**MODIFICATION REQUEST:
Residential Buildings R8 and R9, Barangaroo South
MP 11_0002 MOD 1**

Secretary's Environmental Assessment Report
Section 75W of the
Environmental Planning and Assessment Act 1979

February 2015

7 Section Retail Facade Option A_Fixed glazing
1 : 50

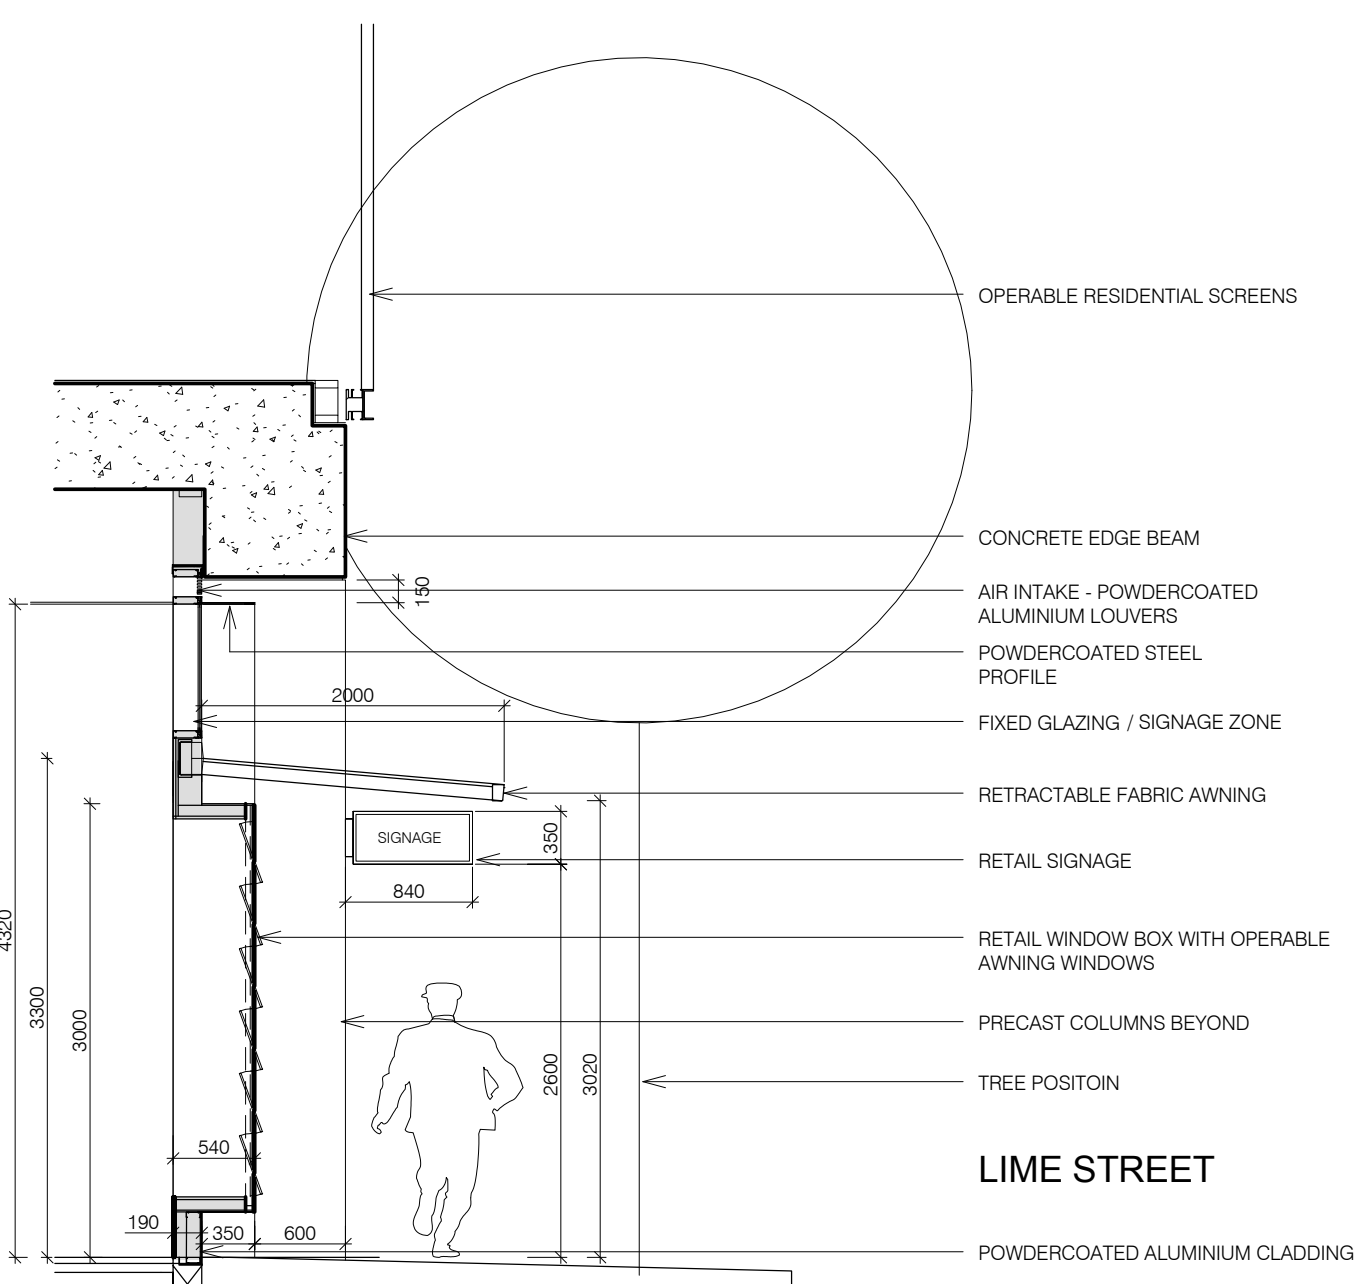
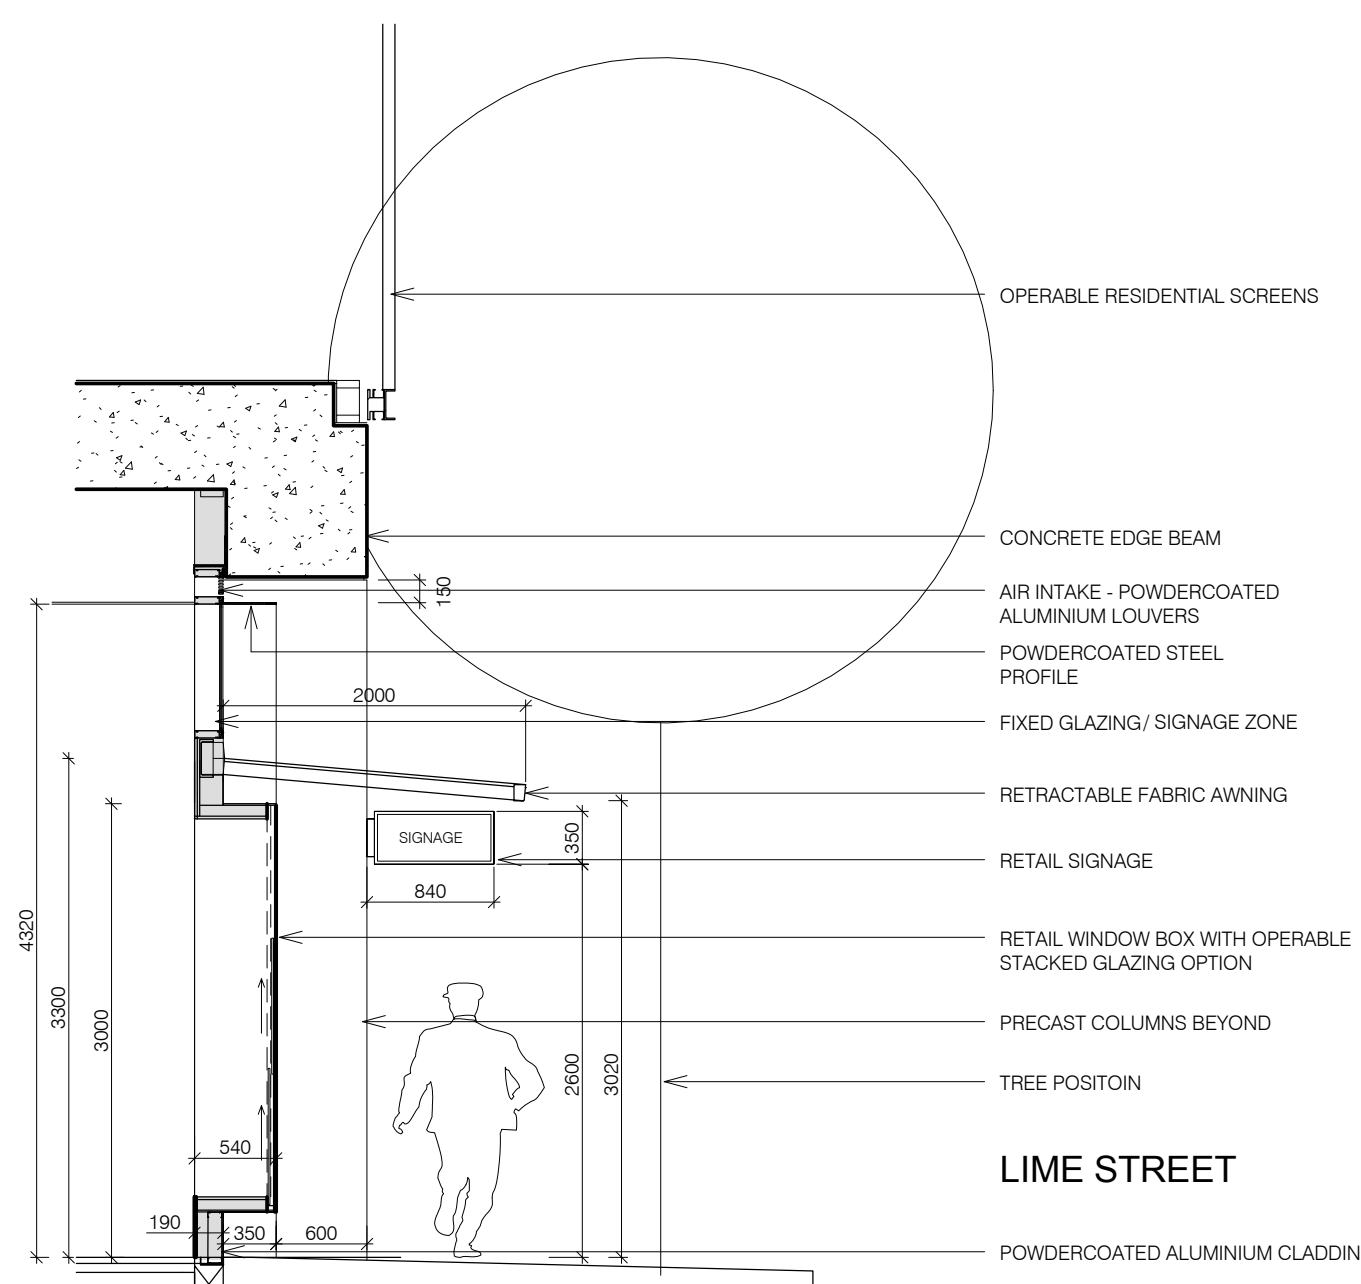
Council raised no objection to the proposed range of retail shop front designs, however, the Government Architect requested further clarification regarding the method for selecting shopfront designs for each of the ground floor retail tenancies. The Department also sought clarification from the Proponent as to whether the retail shop fronts would be constructed under the project approval or as part of the future fit-out applications for the ground floor retail tenancies.

The RTS identified that the retail shop front designs proposed in the modification application are currently only indicative, and that the final detailed designs would be selected by the future tenants according to their design and operational needs. The RTS also identified that the final design of the retail shop fronts would be either undertaken by the Proponent, subject to further approval by the Secretary under the project approval, or the subject of separate future applications by the future tenants themselves. Additionally, the Proponent sought to introduce a new Statement of Commitment (SOC) to secure a framework for the future assessment of the shopfronts for the other elevations (north, south west). The proposed SOC includes general design parameters for each of the shopfronts, namely:

The Department considers that the indicative retail shop front designs with various combinations of glazing and pivot entry and bi-folding doors would generally provide an acceptable outcome for the ground floor retail areas of the buildings fronting Lime Street. The Department also acknowledges the need to provide flexibility for future tenants to tailor the final design of the shop fronts to their needs, and is generally satisfied with the proposed SOC and general design parameters for the shopfronts for the other elevations. Notwithstanding, to provide clarity in the approval, the Department has recommended modifying a number of conditions to specify that no approval is granted to the
